From: Katie Kurek [REDACTED]
Sent: 30 October 2017 13:44
To: Planning.Responses; Simon Davis
Cc: Derek Whittington
Subject: Planning Services Response Re-consultation EG/69/17

SUBJECT: EG/69/17/PL - 4 No. live/work units, Research & Development propagation building & growing area, garden room, fuel store & greenhouse to main dwelling & formation of new access. This application is a Departure from the Development Plan. More Information

Swallowfield, Eastergate Lane, Eastergate, West Sussex, PO20 3SJ

APPENDIX A

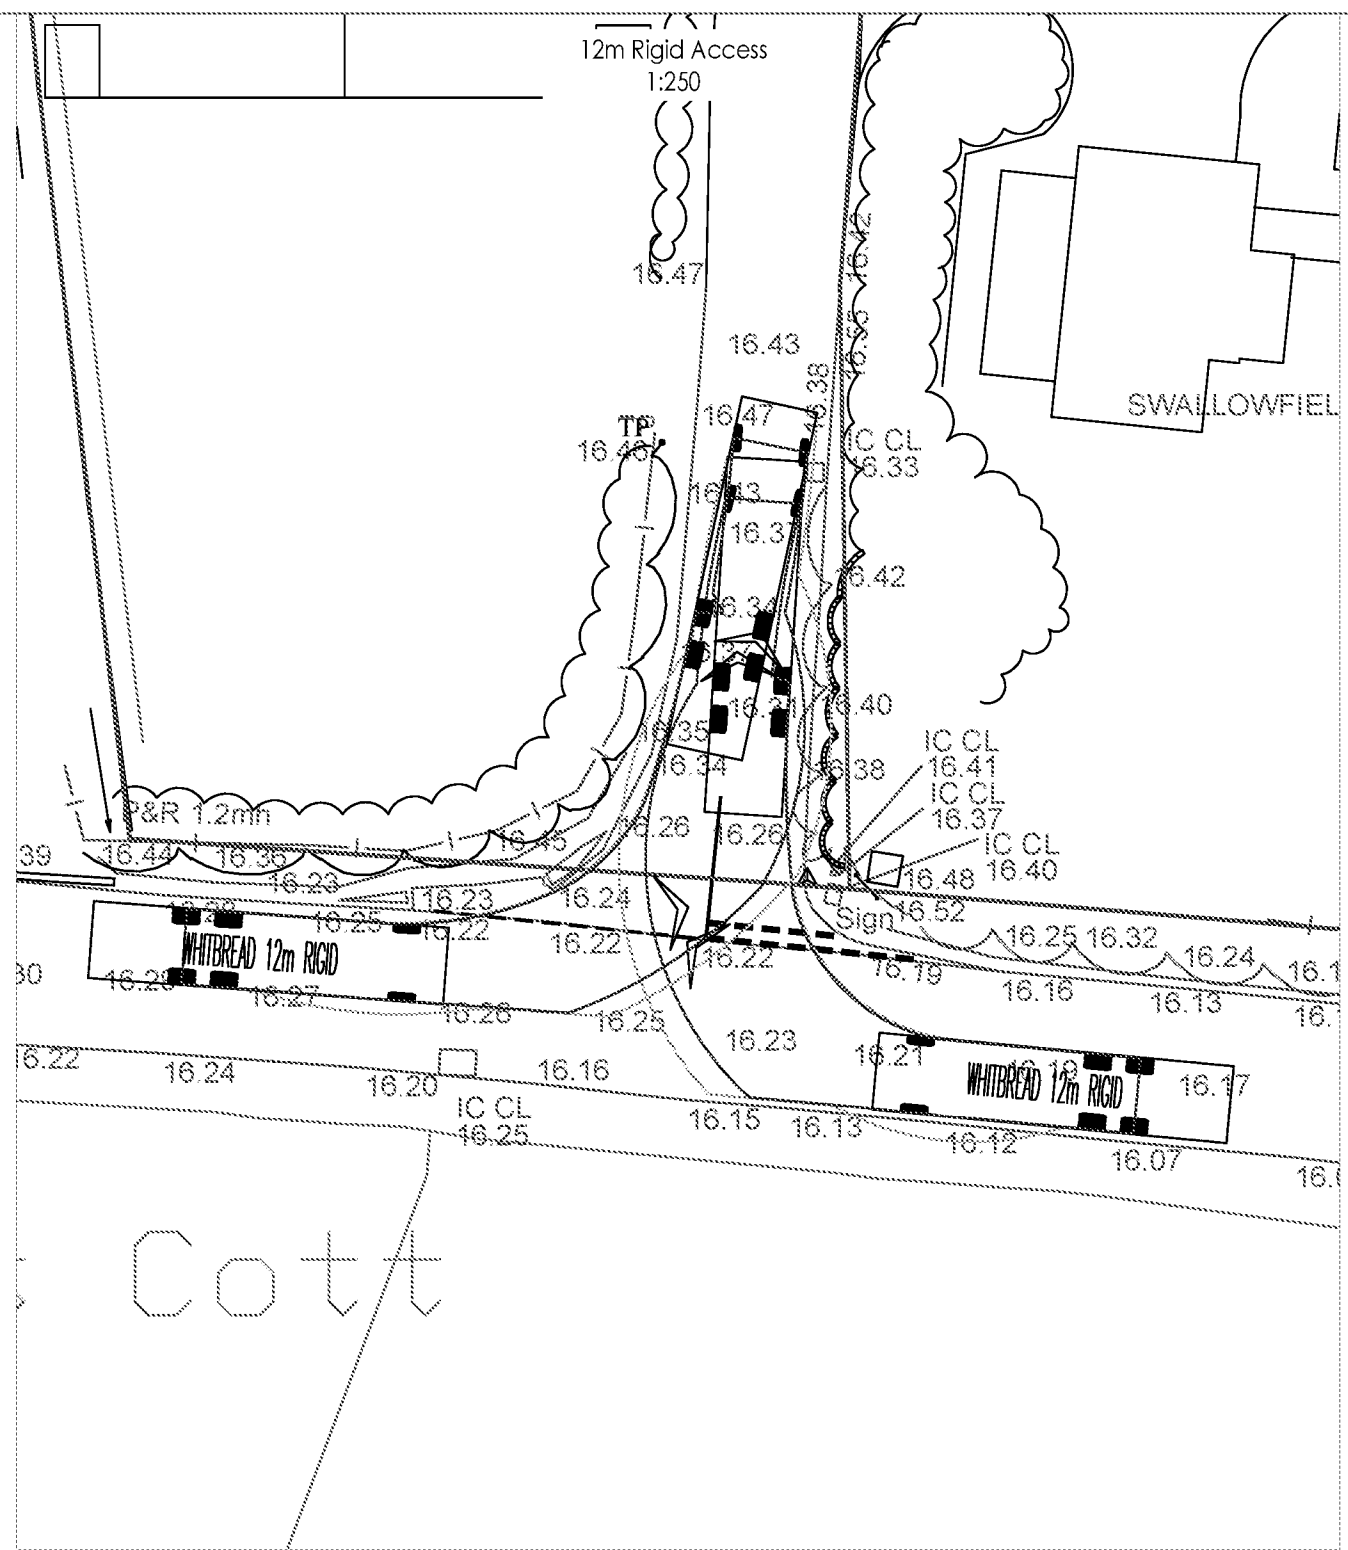
An updated Transport Statement (TS) has been provided along with RSA and Designers Response covering the proposed access works. One problem was identified in the RSA as outlined below:

Problem 3.1 - Risk of vehicle collision was identified as a result of vegetation on both sides of the access roads obscuring sight lines. The Designers Response concurs with the Auditors recommendation that vegetation is removed and regularly maintained to keep the splays in perpetuity.

The LHA are satisfied that the splays are achievable and maintainable with the removal of this vegetation though the Local Planning Authority (LPA) may wish to assess this from a street scene perspective.

Updated and additional swept path plans have been provided demonstrating that two cars can pass in each access and turn within both sites. It has also been demonstrated that larger vehicle (Refuse Collection and Fire Appliance) can access, manoeuvre within each site and egress in a forward gear. The LHA are therefore satisfied that safe and suitable access and appropriate internal layout has been demonstrated for these larger vehicles and that the turning facilities on site are satisfactory.

No part of the development shall be first occupied until visibility splays of 2.4 metres by 103 metres to the west and 2.4 metres by 106.8 metres to the east have been provided at both the existing and new site vehicular access onto Eastergate Lane in accordance with the approved planning drawings. Once provided the splays shall thereafter be maintained and kept free of all obstructions over a height of 0.6 metre above adjoining carriageway level or as otherwise agreed.
